WEST SUSSEX COUNTY COUNCIL CONSULTATION

TO:	Arun District Council FAO: Simon Davis
FROM:	Stephen Gee WSCC - Highways Authority
DATE:	15 March 2019
LOCATION:	10-acre field north of, Grevatts Lane, Yapton, Arundel
SUBJECT:	Y/103/18/PL Single Chapel Crematorium with car parking, landscape works, surface water drainage features & associated highway improvements. This application is a Departure from the Development Plan. More information.
DATE OF SITE VISIT:	15/01/19
RECOMMENDATION:	No Objection
S106 CONTRIBUTION TOTAL:	£ See below for breakdown.

PBA drawing 128.001.007 Rev D

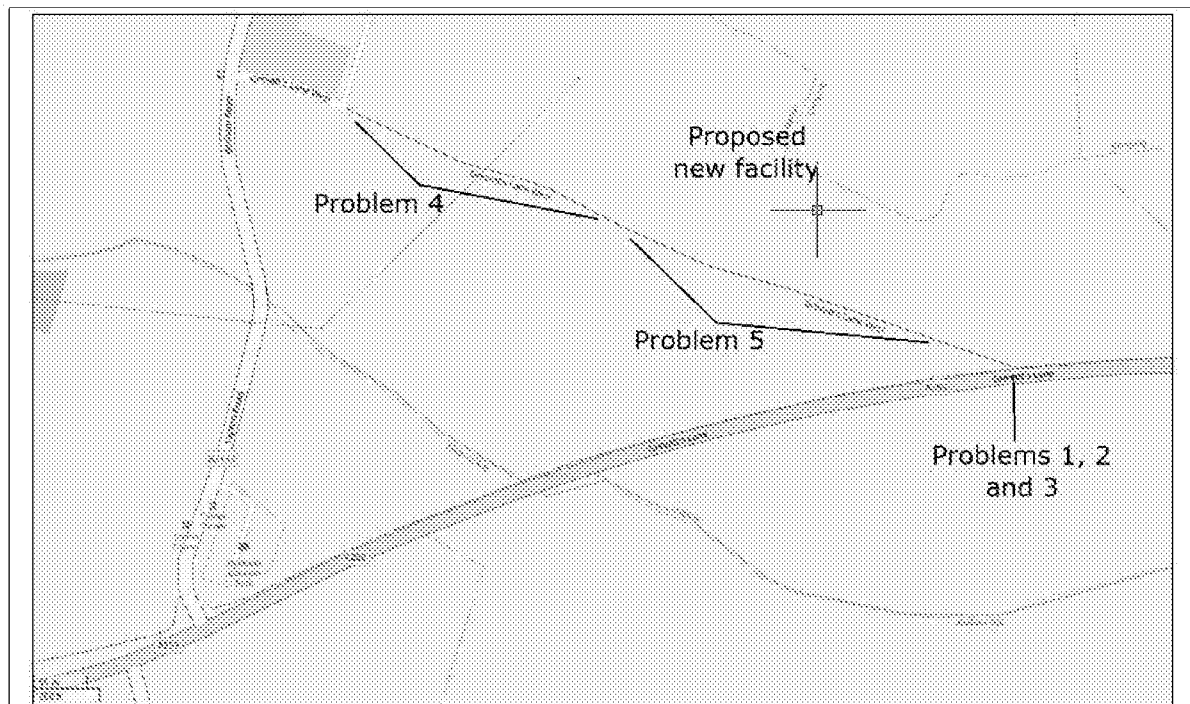
No part of the development shall be first occupied until such time as the vehicular access serving the development has been constructed in accordance with the details shown on the drawing titled Access Road Amendments and numbered 128.001.007 Rev C.
